City of Albuquerque  
Planning Department  
Development Review Division  
P.O. Box 1293  
Albuquerque, New Mexico 87103

## AMENDED OFFICIAL NOTIFICATION OF DECISION

FILE: Project # 1004675  
06EPC-00140 EPC Site Development Plan-  
Subdivision

2. The applicant proposes design standards for the Vistas de La Luz project—a planned residential development (PRD) consisting of 67 single-family homes and 72 townhomes (139 units total). Two future areas are reserved for C-1 and O-1 permissive uses with exclusions.

**SITE PLAN FOR SUBDIVISION
 VISTAS DE LA LUZ
 SUBDIVISION**

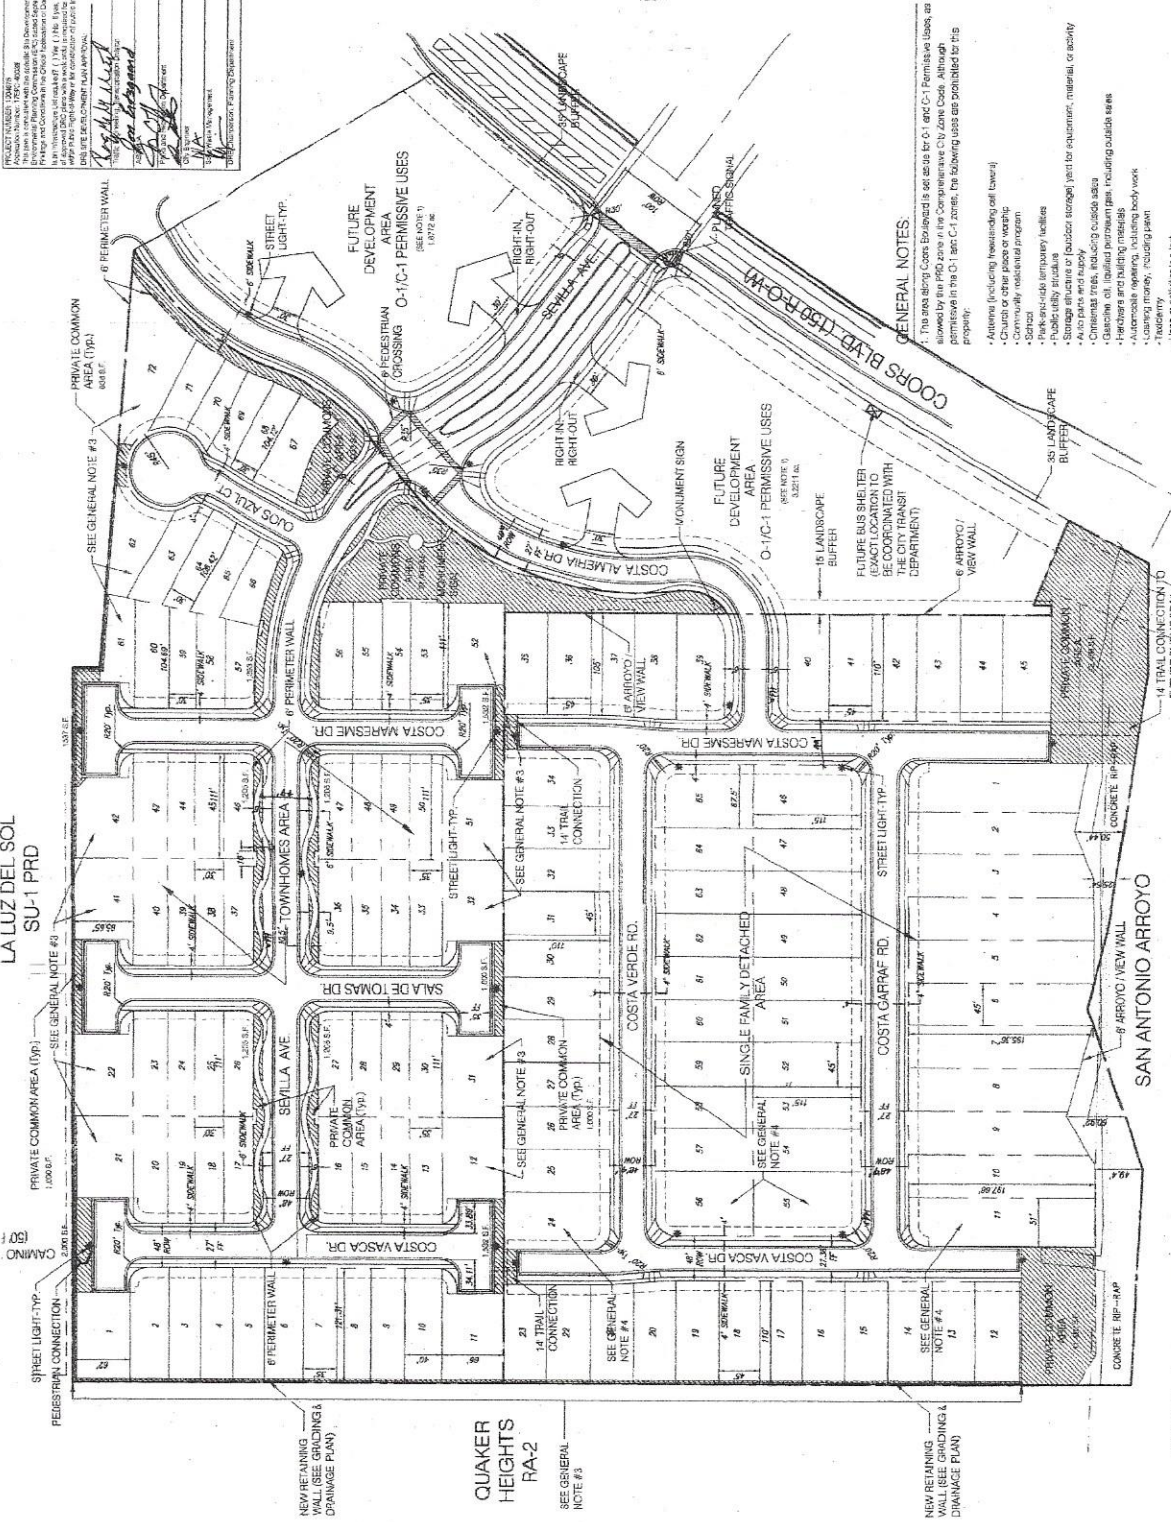
15. Add a transit shelter south of Maduri Drive.
  16. The second sentence under General Note #3 on sheet 1 shall be clarified that the lots it references are within north townhome area.

Perimeter Wall Elevation

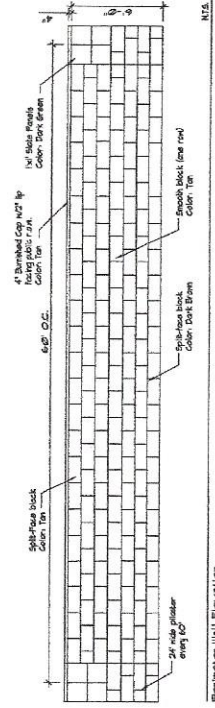
17. The note regarding railroad ties shall be removed from the grading & drainage plan.
  18. Sheet #3: the wall detail for the arroyo perimeter wall shall be for the arroyo perimeter wall and the east perimeter wall.
